**RE: 64<sup>th</sup> Street Subdivision**  
**4221 64<sup>th</sup> Street NW**  
**Grading and Drainage Plans**  
**Engineer's Stamp Date: 08/06/2025**  
**Hydrology File: F10D067**  
**Case # HYDR-2025-00294**

Based upon the information provided in your submittal received 08/14/2025, the Grading & Drainage Plans **are not approved** for Grading Permit or Building Permit. The following comments need to be addressed for the approval of the above referenced project.

DESIGN REVIEW COMMITTEE: [Blank] CITY ENGINEER APPROVAL: [Blank] ZONE MAP NO. F-10-Z
CITY PROJECT NO. ###
SHEET NO. CG-100

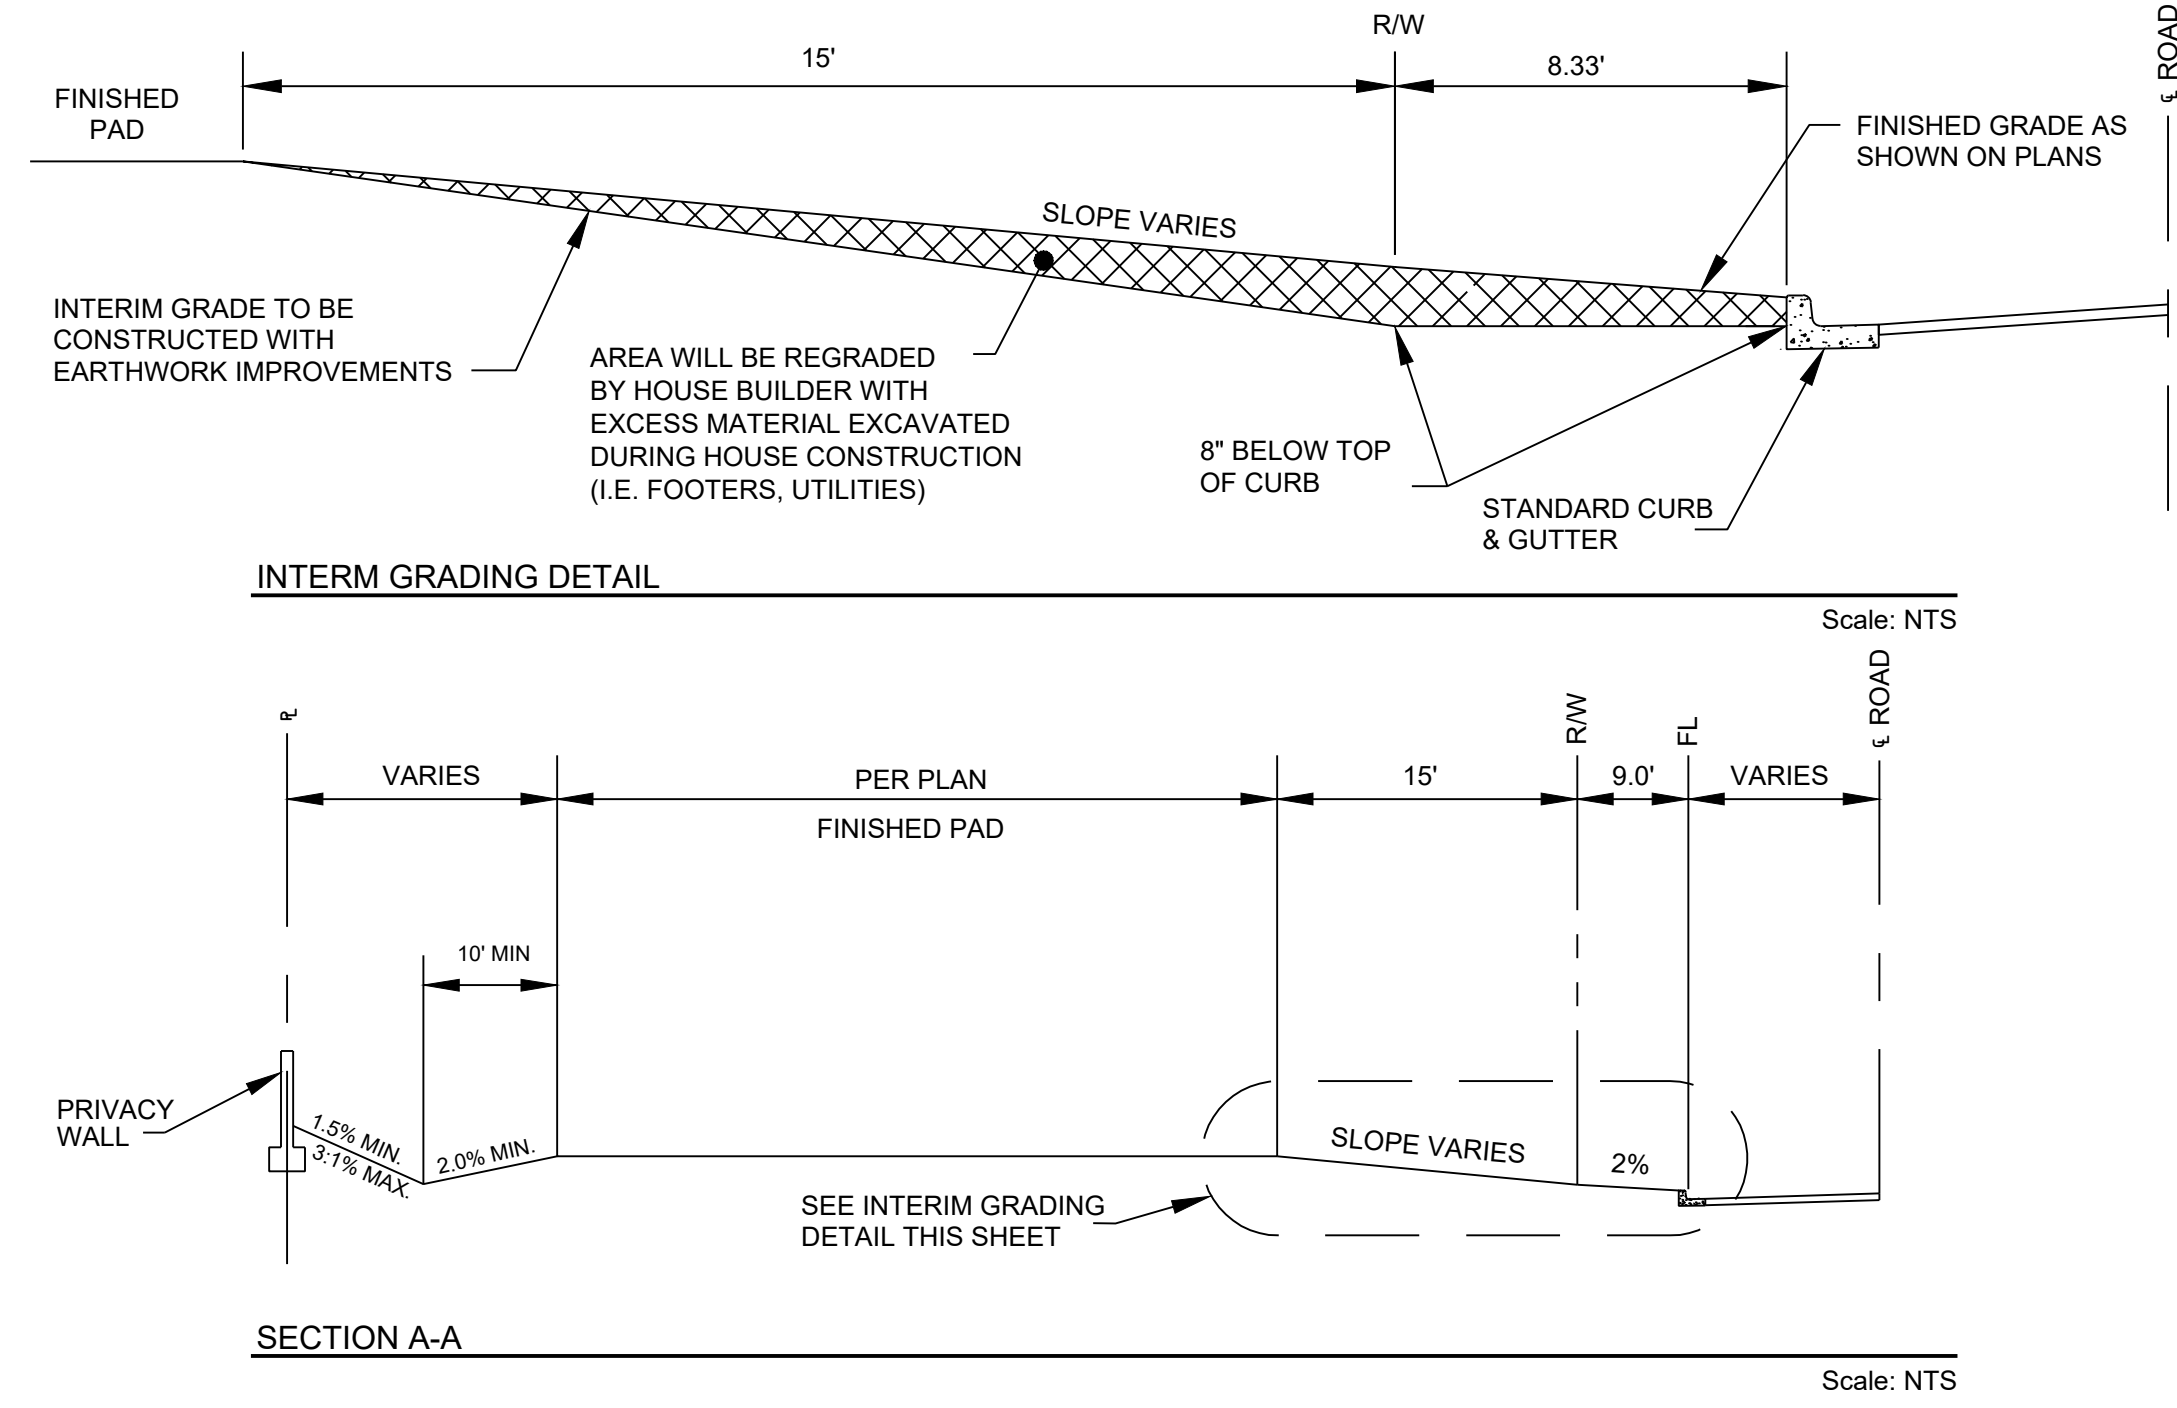
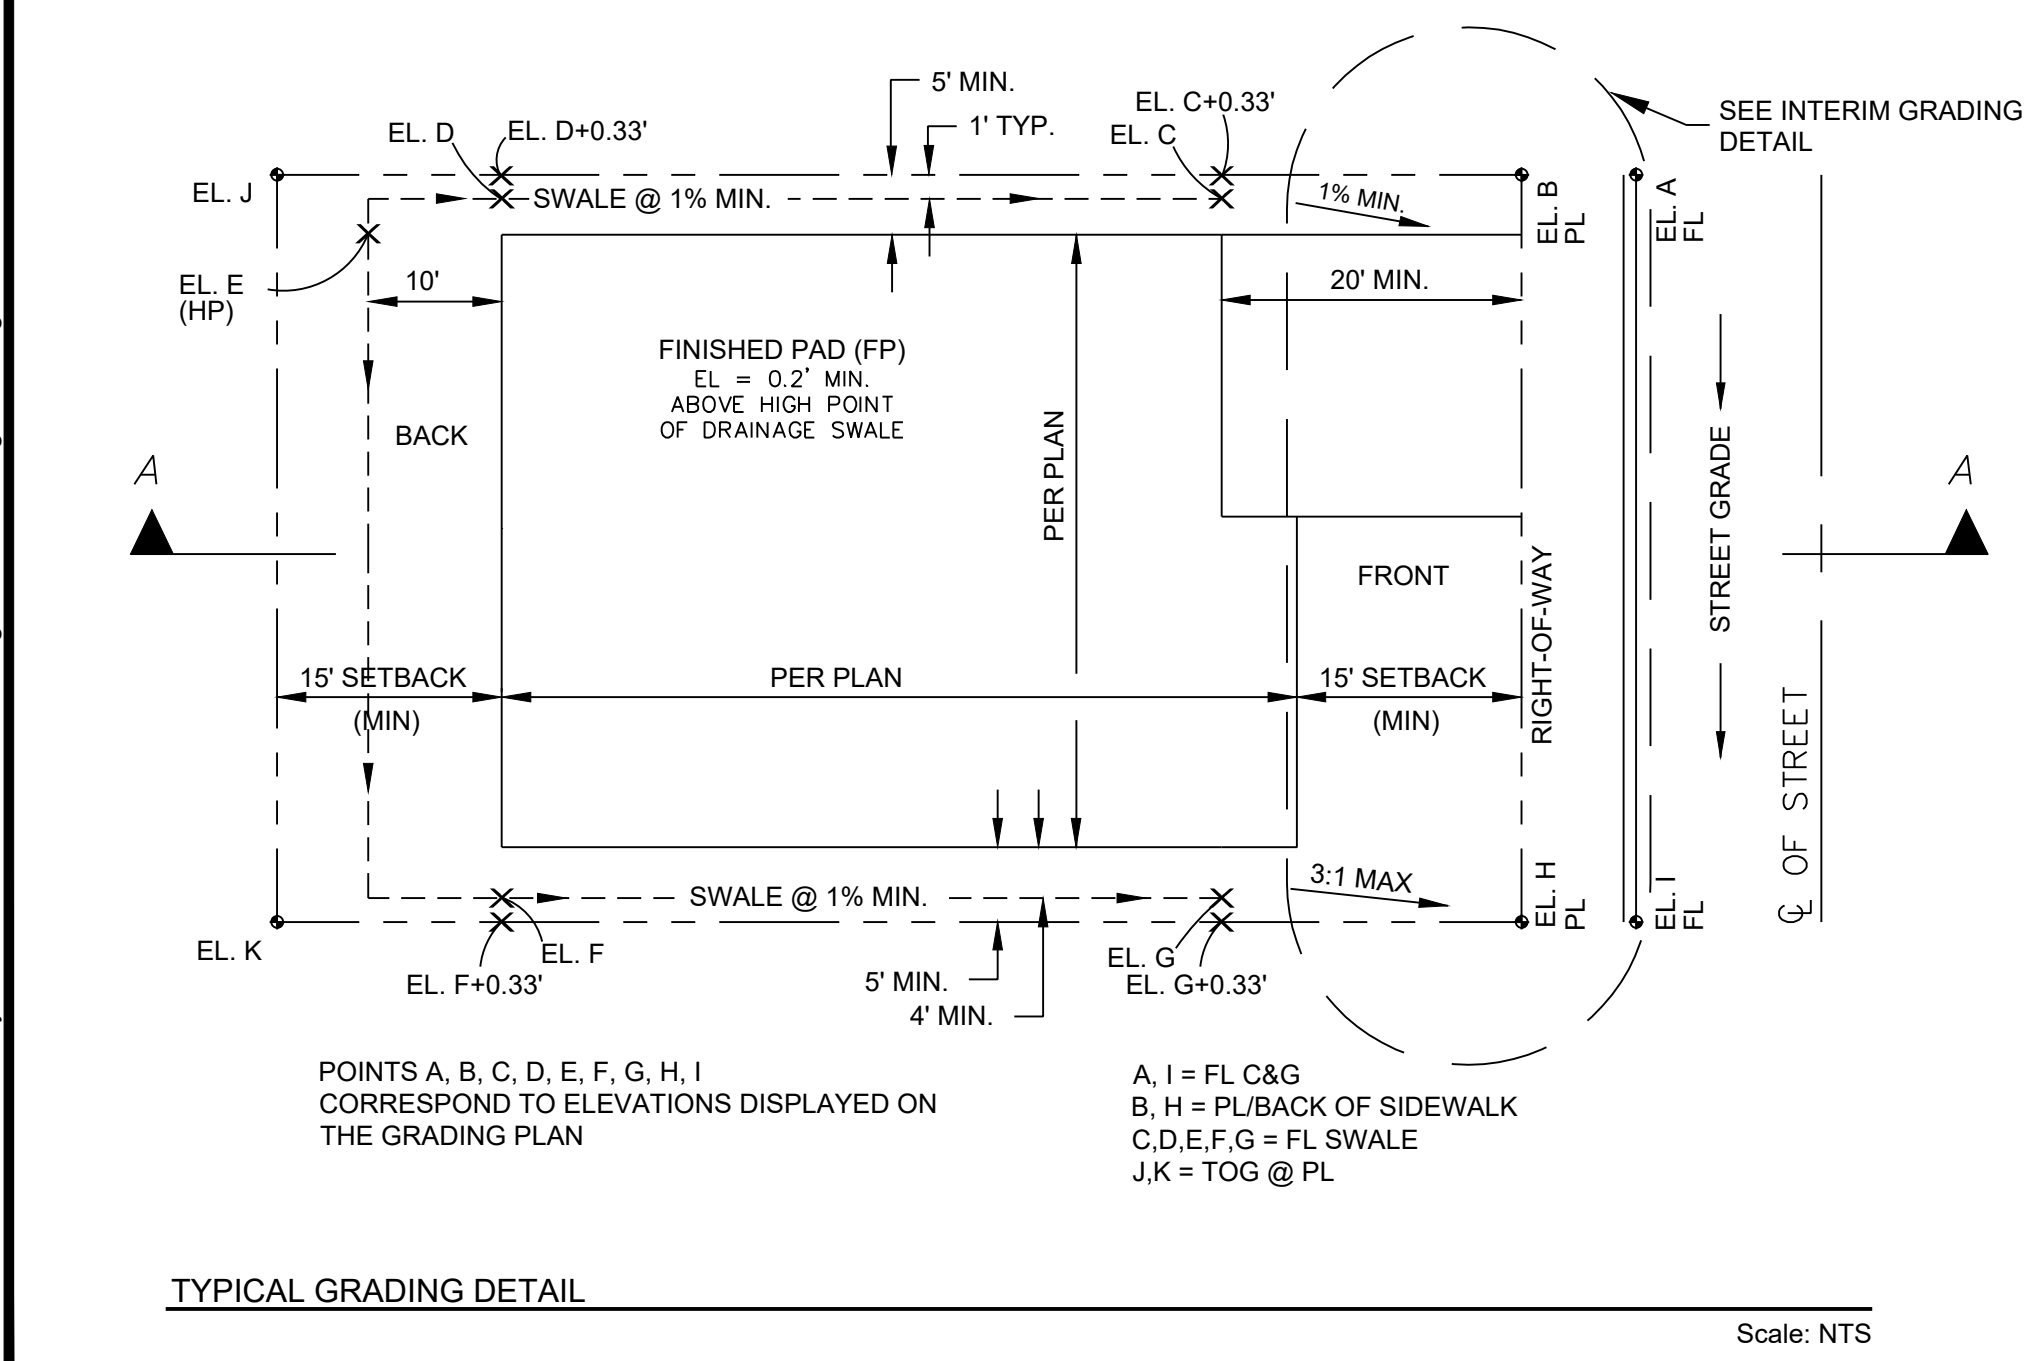
3. Identify internal retaining walls to be constructed by the developer (prior to Pad Cert) and those to be deferred to homebuilder. Any wall retaining 2 feet or more will need to be constructed by the developer (i.e prior to Pad Cert); less than 2 feet retained can be deferred to homebuilder.
4. CG-101 – Remove Grading Note #3 – Retaining walls less than 2 feet are not shown. See comment #2.
5. CG-101 – Grading Note #2 – The Retaining Wall Elevation Table is missing from this sheet.
6. There appears to be a retaining wall on 64<sup>th</sup> east of Lot 3. Provide the existing and proposed grades on both sides of the proposed retaining wall.
